**From:** Longridge Town Council <clerk@longridge-tc.gov.uk>  
**Sent:** 05 April 2022 10:49  
**To:** Planning  
**Subject:** 3/2021/0275 Land behind The Dog Inn, Market Place, Longridge PR3 3RR  
**Categories:** To Upload

### 3/2021/0275 Land behind The Dog Inn, Market Place, Longridge PR3 3RR

Planning Application  
Elevations

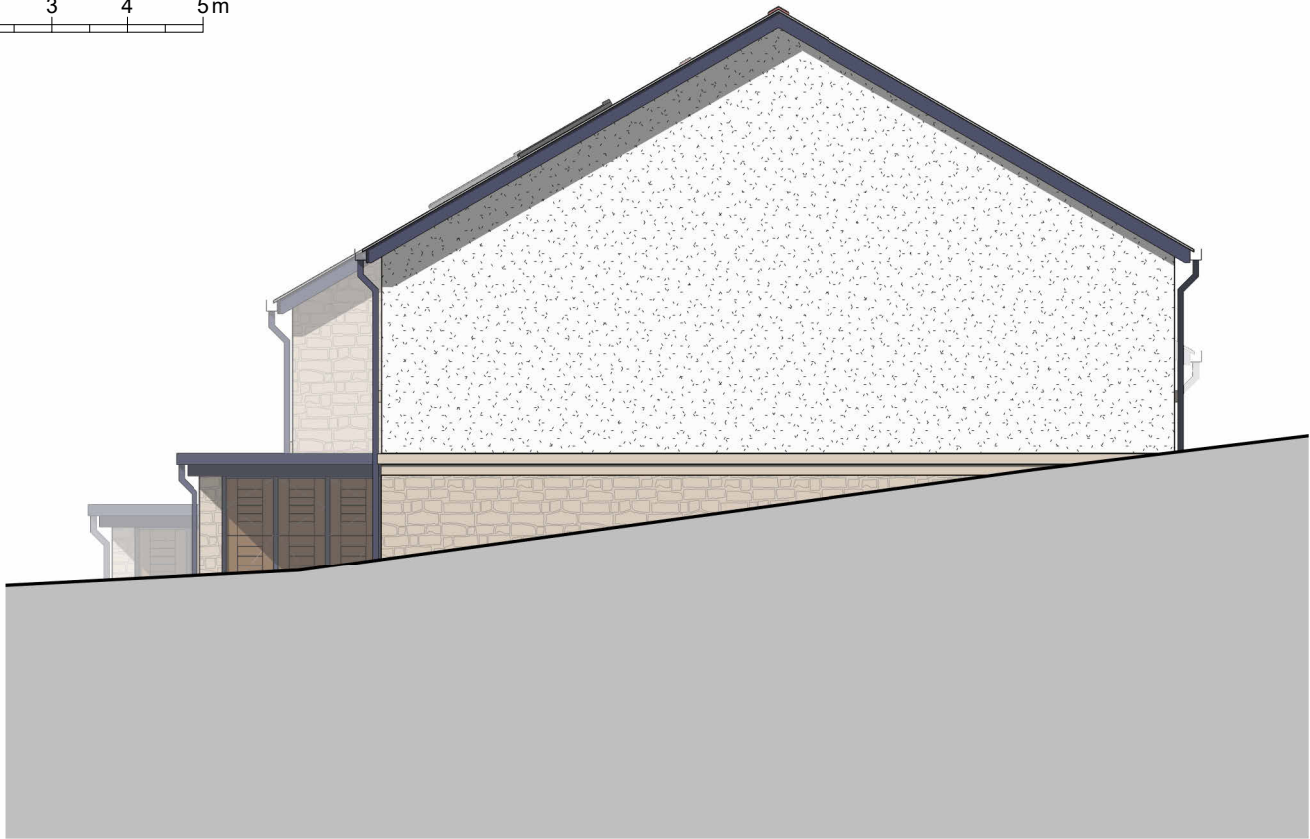
Longridge Town Council discussed the above application at their meeting on 9th February. The Council discussed the style of the buildings and commented that the use of white rendering was not in keeping with the area. The Council also asked that concerns of the residents in neighbouring properties about overlooking and privacy be taken into consideration.
